From: Amanda Scholes on behalf of Planning.Responses
Sent: 22 August 2019 10:51
To: Planning Scanning
Subject: FW: Planning Consultation on: BN/57/19/RES

App No: BN/57/19/RES
Address: Land East of Fontwell Avenue Fontwell Avenue Fontwell BN18 0SB
Proposal: Approval of reserved matters following the grant of WA/22/15/OUT for a 2 No. non-residential buildings.

Liz Annalls
Environment Officer
Environmental Protection
Chichester District Council

Draw No RA/032/50 SITE PLAN A

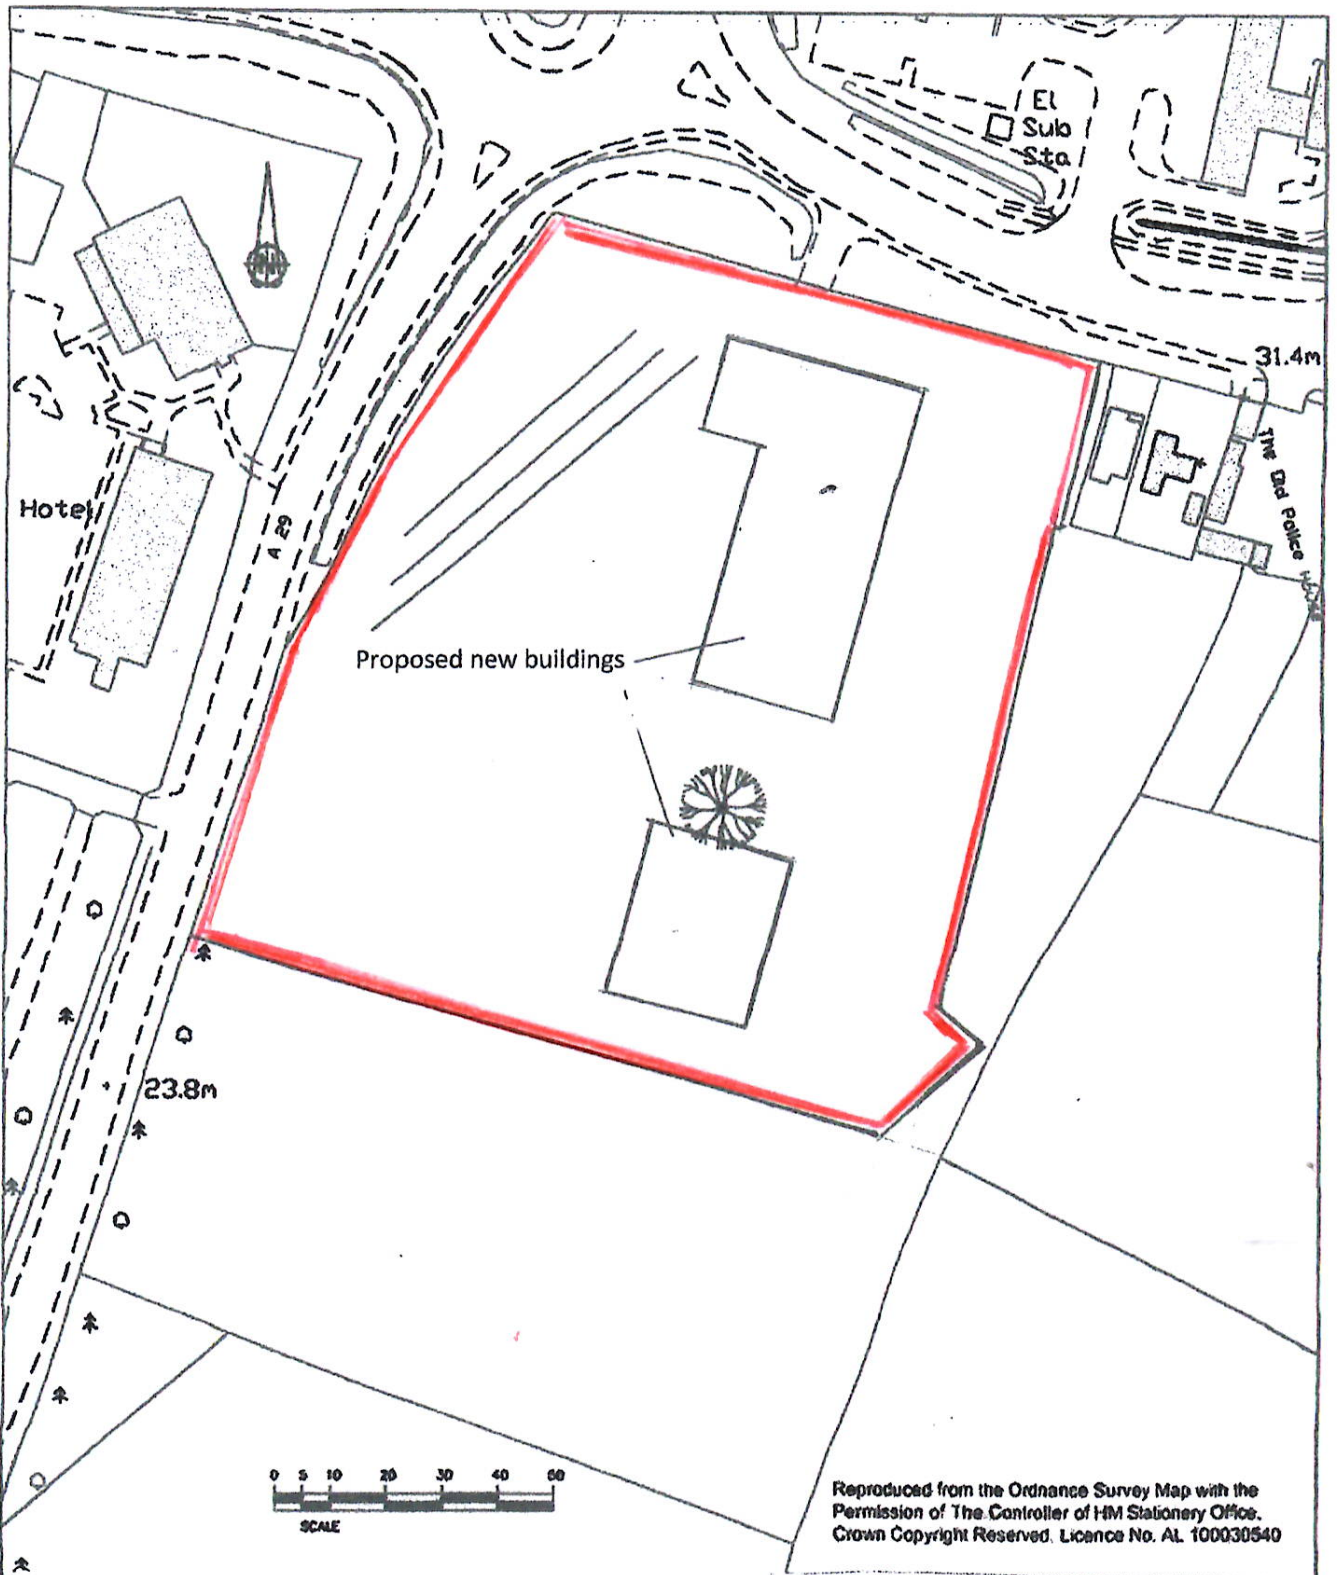
No information has been submitted relating to the landscaping of this area, please can information relating to this be submitted detailing what vegetation is being retained and what is being planted.

No information has been submitted detailing the lighting strategy for this area of the site. The lighting scheme will need to take into consideration the presence of bats in the local area and the scheme should minimise potential impacts to any bats using the trees, hedgerows and buildings by avoiding unnecessary artificial light spill through the use of directional light sources and shielding. Please can information relating to this be submitted as part of this application.
